OFFICIAL NOTIFICATION OF DECISION

Project# PR-2022-006708
Application#
SD-2023-00028 PRELIMINARY/FINAL PLAT

For all or a portion of: **LOT 6, FOUR HILLS VILLAGE 21ST INSTALLEMENT** zoned **R-1D**, located at **1200 HIDEAWAY LN SE between STAGECOACH RD SE and I-40** containing approximately **3.0791** acre(s). **(M-23)**

**PLAT OF
LOT 6-A
FOUR HILLS VILLAGE 21st INSTALLMENT**

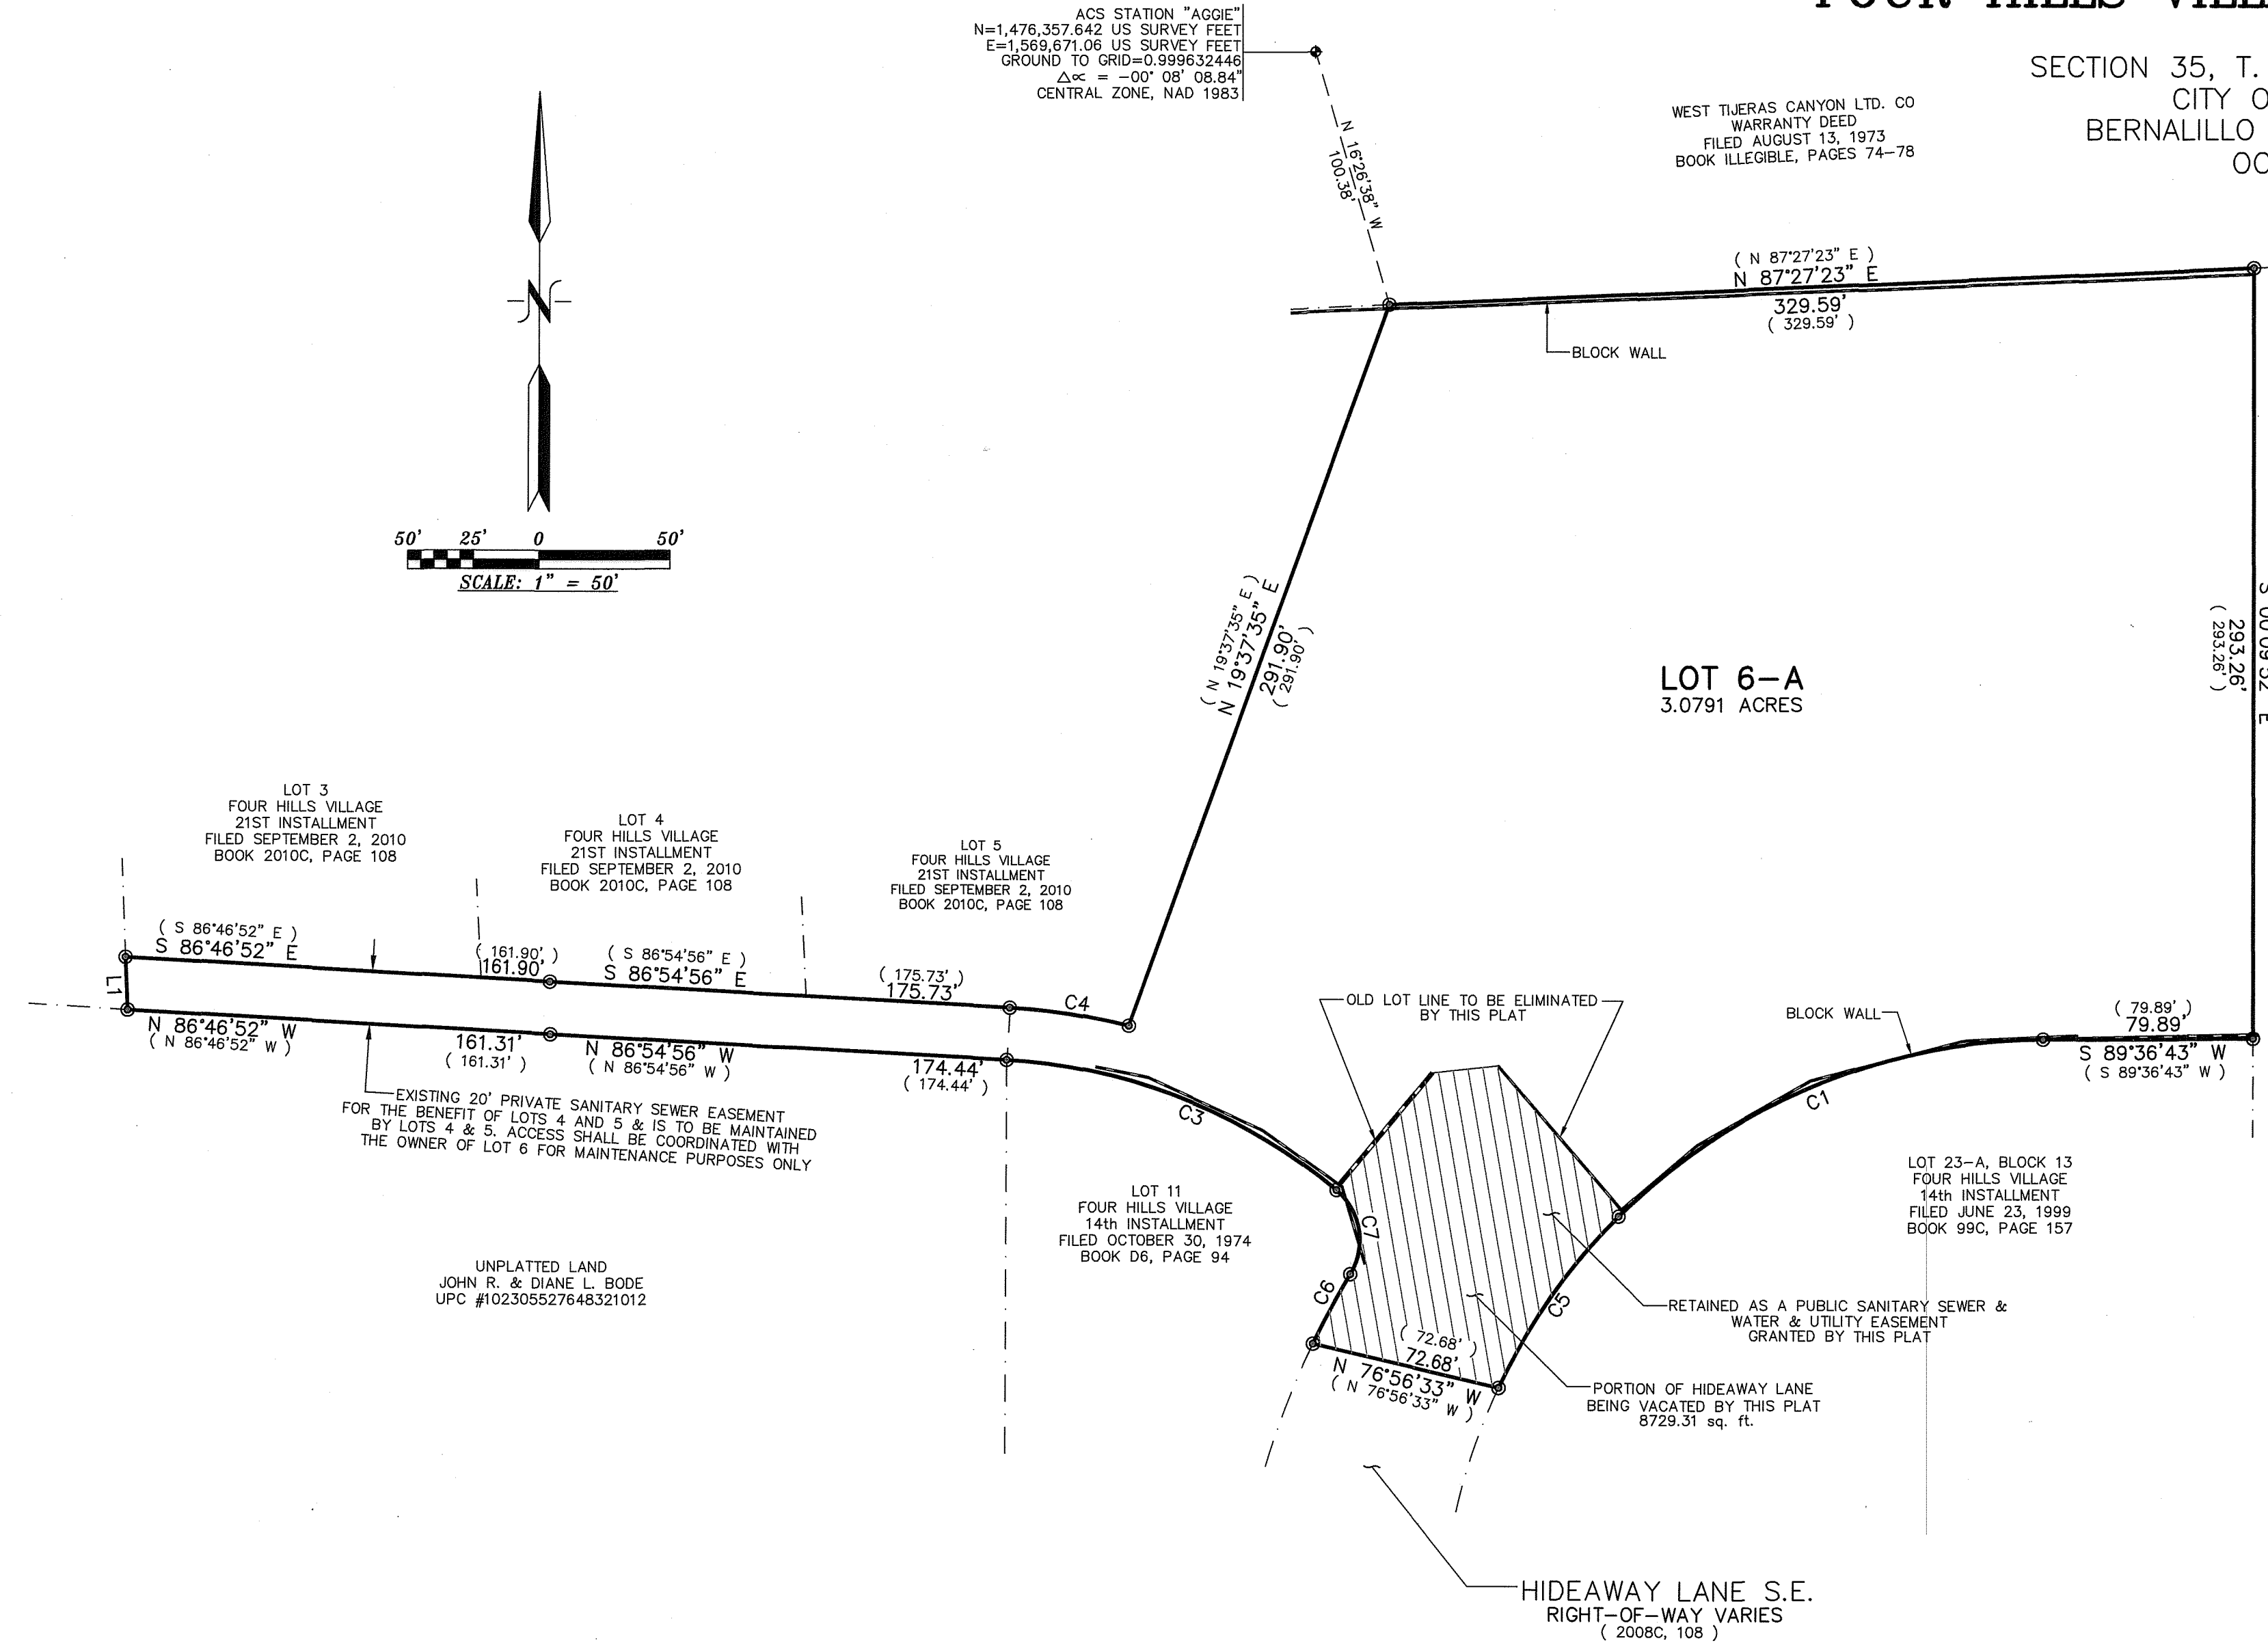
- a. The DXF file approval email from AGIS must be submitted.
- b. The application number must be added to the Plat.

- c. The project and application numbers regarding the right-of-way vacation and the date of City Council approval must be included as a note on the Plat.
- d. A note indicating the 45-ft major public open space buffer per IDO 5-2(K)(2)(a) must be added to the Plat.
- e. A private drainage easement and note should be added to the Plat indicating that the property owners shall maintain the existing storm inlet and storm pipe.
- f. Line spots must be added to the Plat indicating where all utilities are located.
- g. An exclusive 20-ft easement to ABCWUA must be provided with defined limits and to note any overlapping of the drainage easement.
